Recommendation Report for Works to Tree(s) on trees subject to a Tree Preservation Order (

REF NO: FP/153/17/T

LOCATION: Priory Garty
16 Roundle Square
Bognor Regis

PROPOSAL: 3m crown reduction to 1 No. Copper Beech.

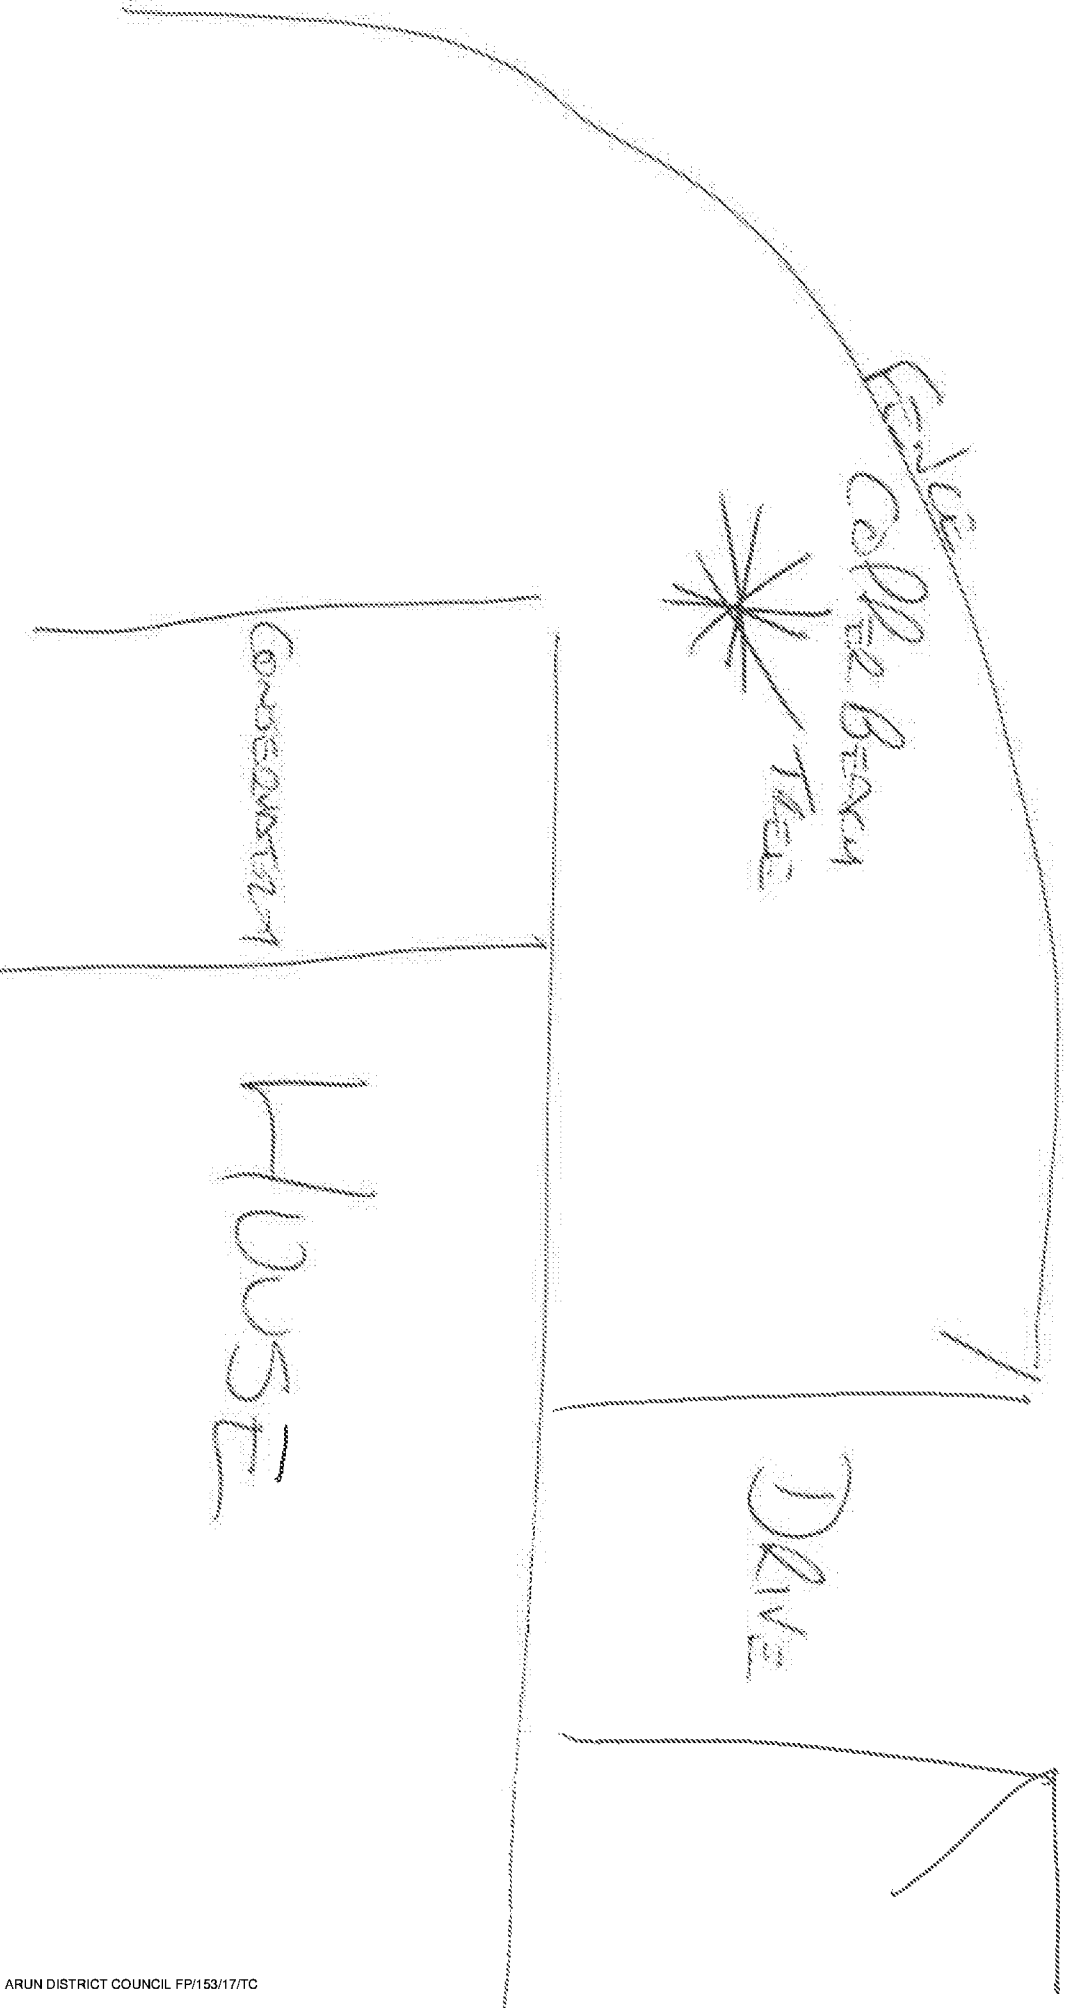
- A mature tree of low spreading proportions due to previous pruning regime.
- Due to its dense canopy and low branching habit and dark purple leaf It causes shading of the front garden being positioned to the south side of same.
- I would support some pruning work to keep this tree under control.

- The proposal to reduce the height and spread by 3m exceeds the recommendations of BS3998 and would be likely to result in harm to the health and vitality of the tree with large pruning wounds being formed as well as undermining its visual amenity value and impact in the landscape.

- 1. Reduce the overall height of the tree by 2.5m to 3m.
- 2. Reduce the length of the lateral branches of the tree in an even and balanced fashion by up to 1.5m maximum.
